**From:** Simon Davis  
**Sent:** 15 April 2019 12:26  
**To:** 'Nigel Locke'  
**Subject:** FP/64/19/PL Mow Cottage

SITE PLAN 1:500 @ A3

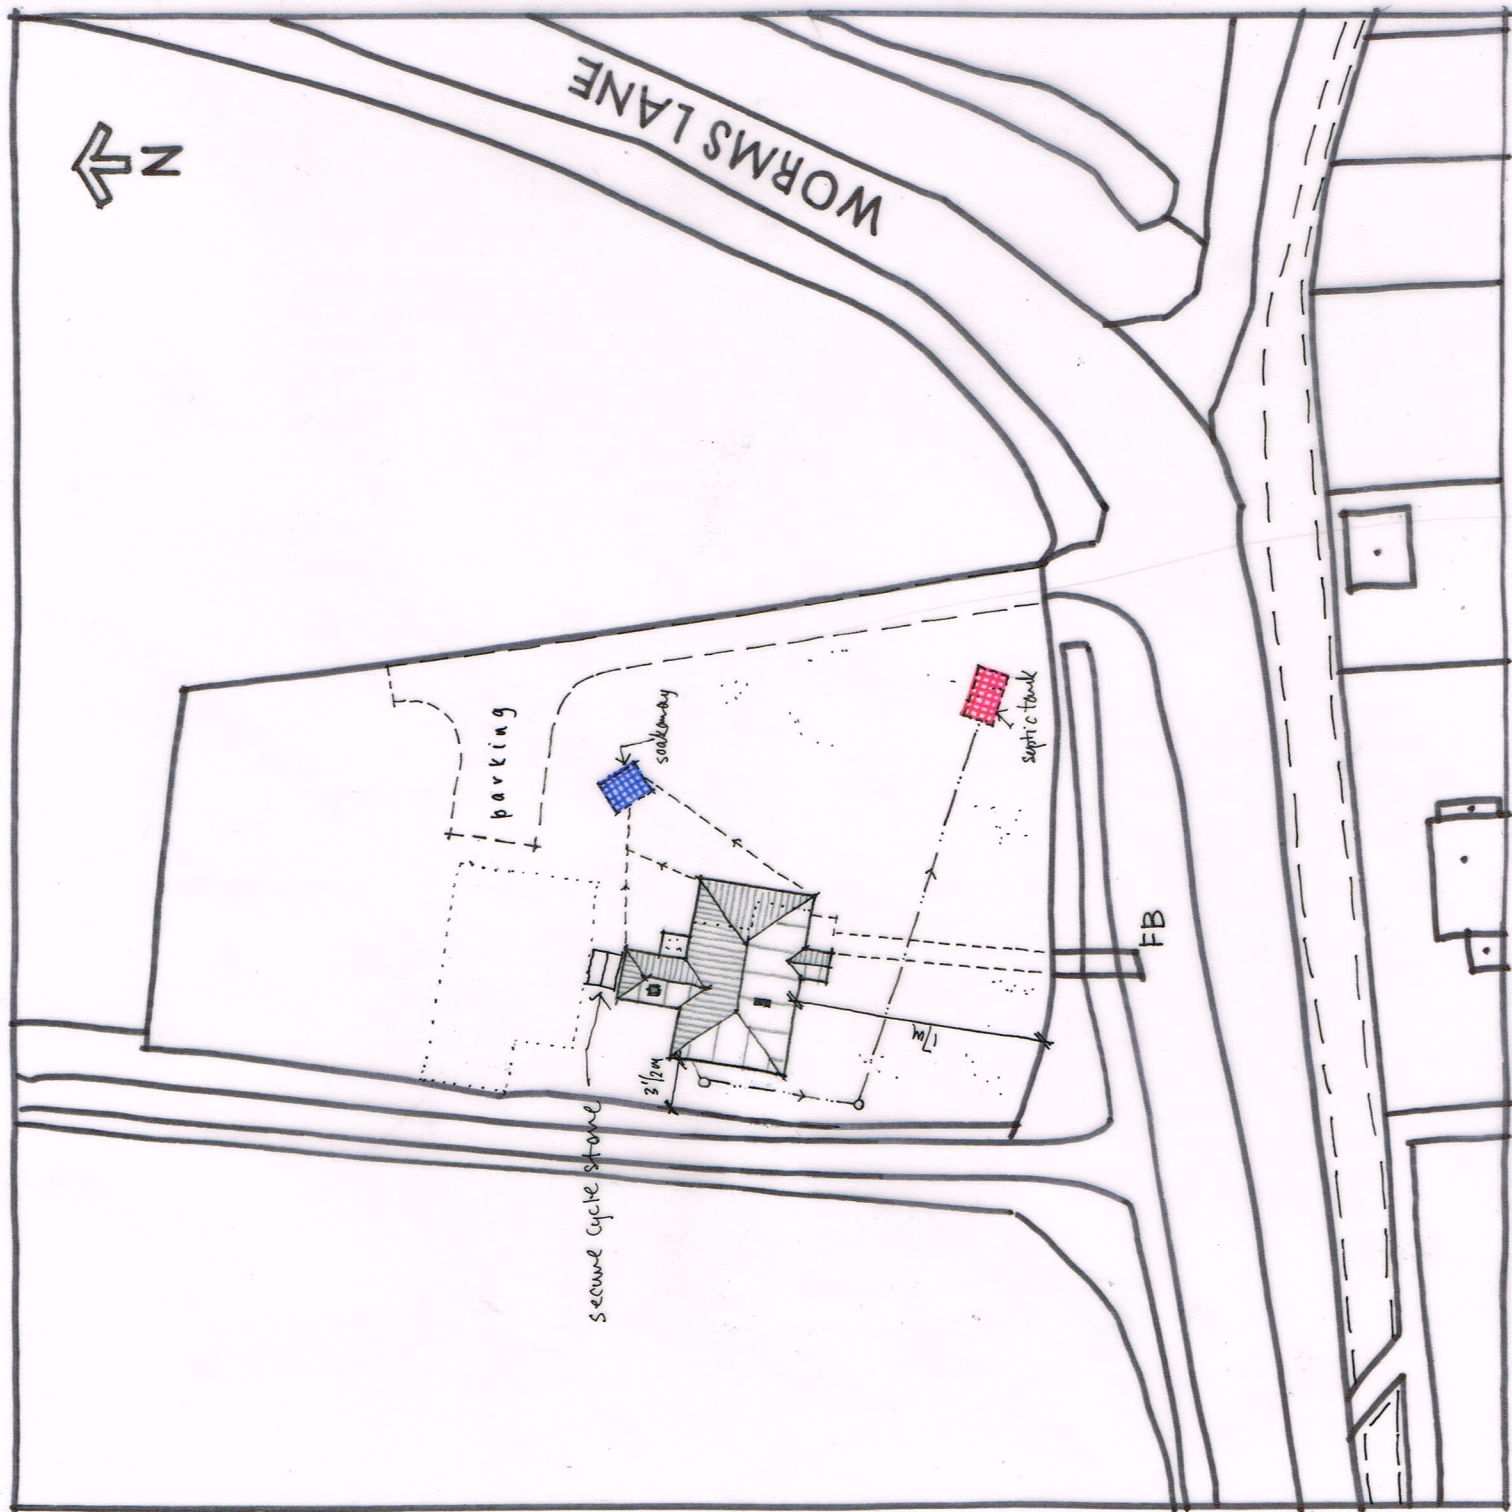
“The plans do not show any refuse and recycling collection arrangements, although Manual for Streets does state that residents should not have to travel over 30m to put bins out and collection vehicles should not have to travel in excess of 25m to collect/deposit bins. This is however a matter of amenity for the Local Planning Authority (LPA) to consider. The applicant is advised to contact the waste disposal authorities to ascertain whether the practise would be acceptable.”

I have today spoken with our Cleansing Operations Manager and he has said that a Council refuse vehicle would not be able to go down Worms Lane to pick up bins and that collection should instead be from the junctions of Worms Lane and the A259 (where a refuse vehicle could pull in briefly).

We will therefore likely add an informative to any decision to alert the applicant to the likely refuse collection arrangements and the need to agree this with the Council.
